Application for DCO by FOSSE GREEN
Representation by Interested Party reference [REDACTED]
Deadline 5

Summary of Submissions

Drawing file: published-documents / EN010154-000388-6.2 Fig 3-3 Permissive Paths.pdf

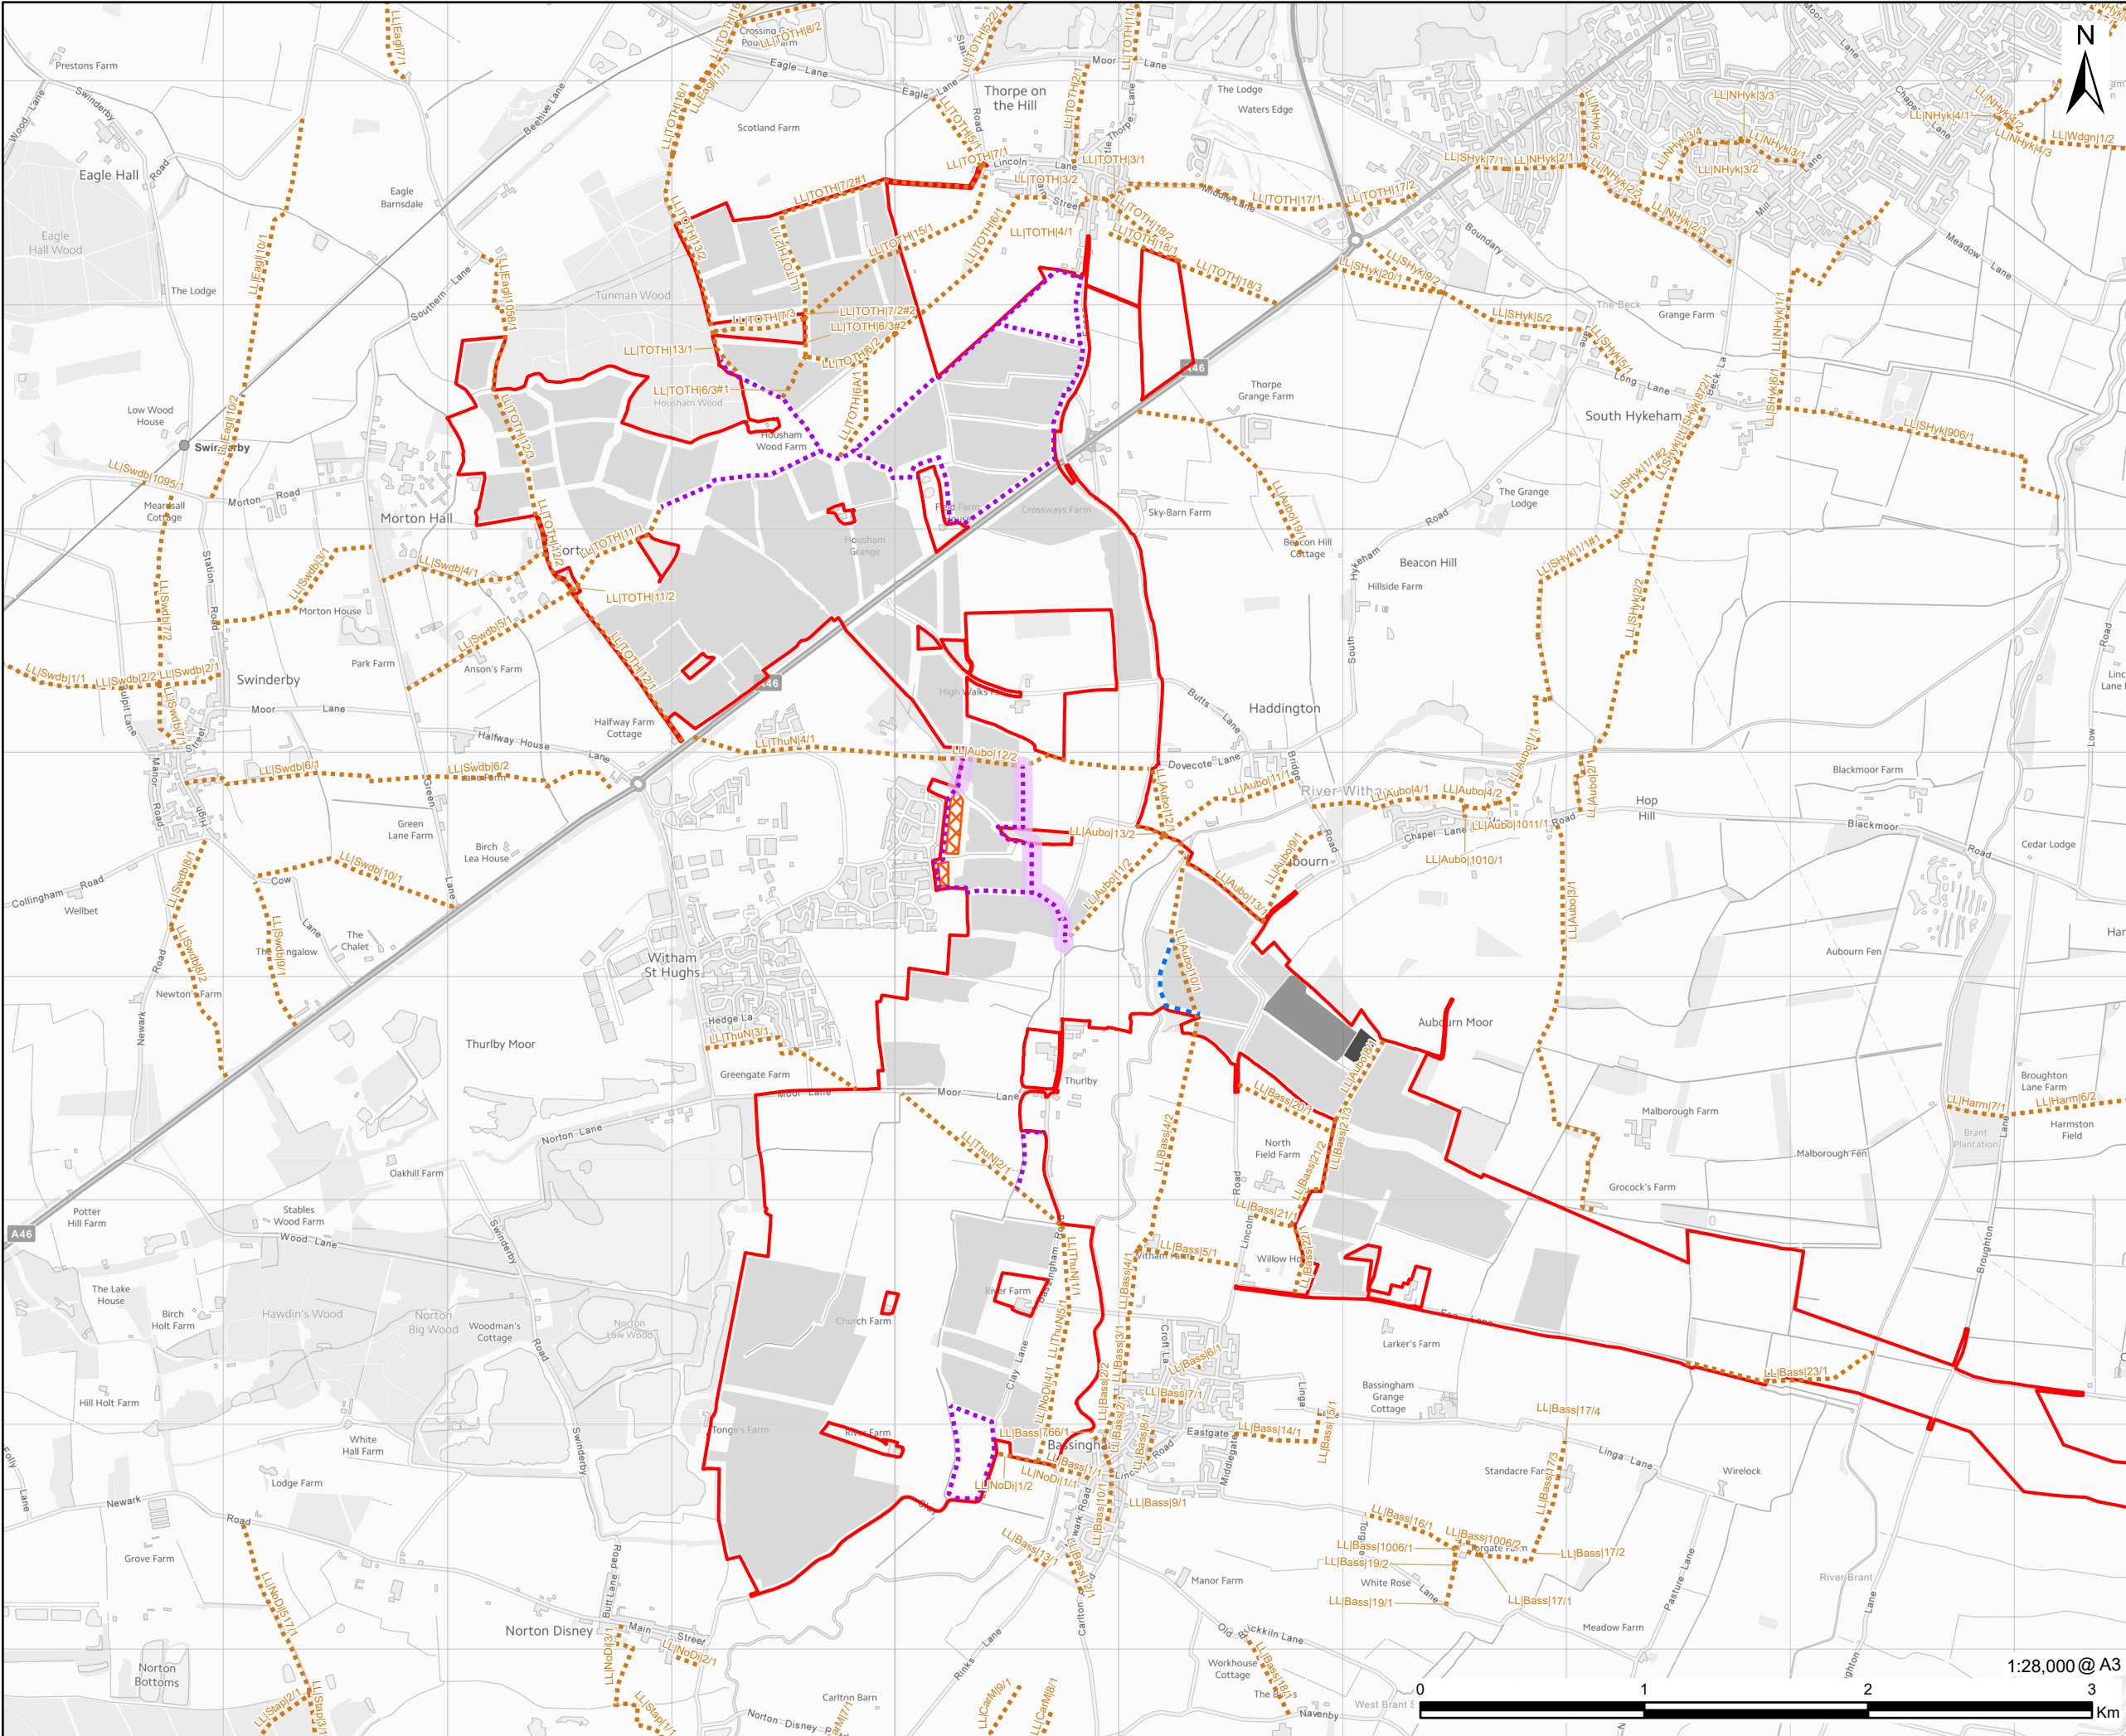
As I have already pointed out in paragraph 3.3.2 of my submission REP2-061, Clay Lane is a public highway over which there are existing rights of way for pedestrians. The Applicant should therefore amend these plans accordingly to remove this length of “permissive path”.
